## Aquind Interconnector Project

Application for a Development Consent Order

## **Deadline Seven C Comments**

## **East Hampshire District Council : Deadline Seven C comments**

Plate 6 - Proposed construction traffic management on Day Lane - will be replaced with full page image when issued as PDF

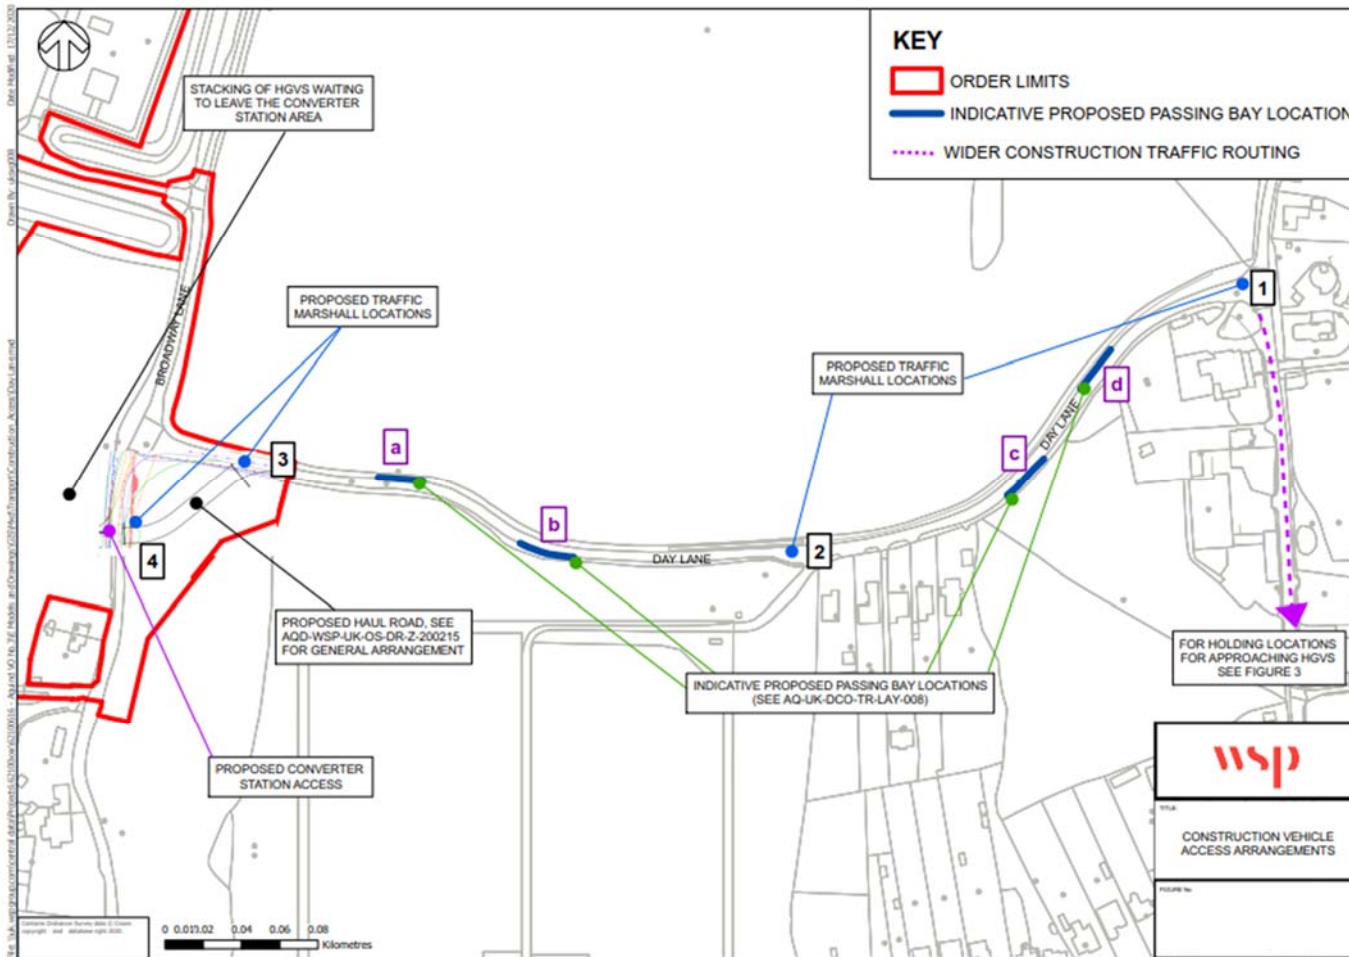
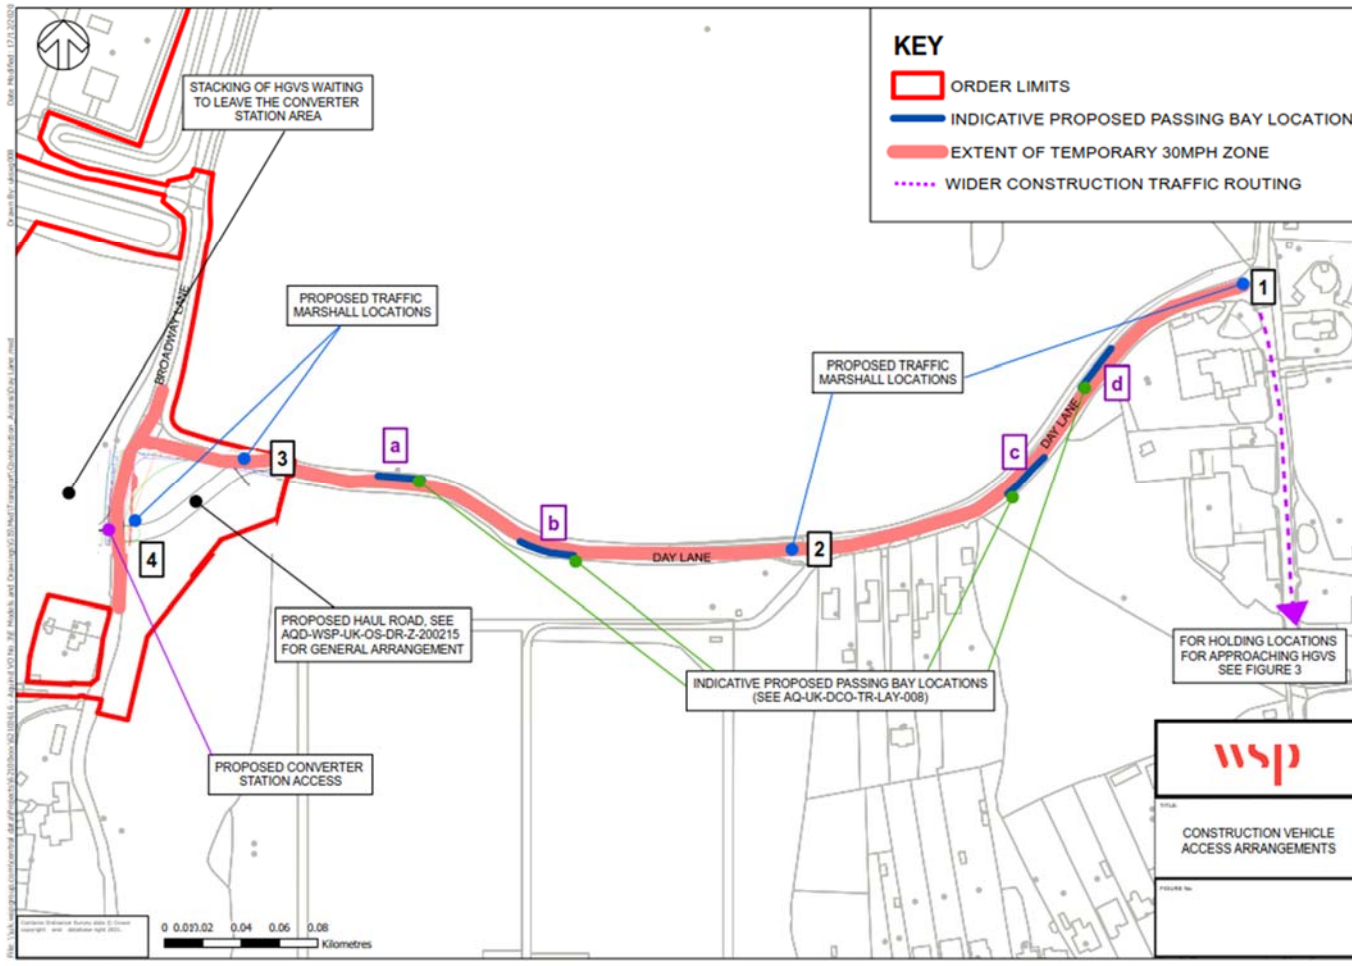
1.1 Hampshire County Council will lead in the response to The Day Lane Technical Note and the management of construction traffic. EHDC however, is not concerned about the landscape impacts of the proposed passing bays in principle; designing in passing bays is preferable to HGV's habitually driving over verges causing potentially greater visual or ecological impact. That said, landscape harm could arise through damage or loss to trees, particularly the trees in the approximate location of passing bay 'b'. EHDC would highlight the importance of retaining trees and protecting their root zones, but note this would be secured through a s.278 process. Similarly, any issues regarding the ordinary water course on the northern side of Day Lane where passing bays 'a' and 'd' are proposed should be safeguarded through the s.278 agreement. We would not want to see poorly constructed passing bays that quickly become potholed, which could result in visual harm to the character of the rural road.
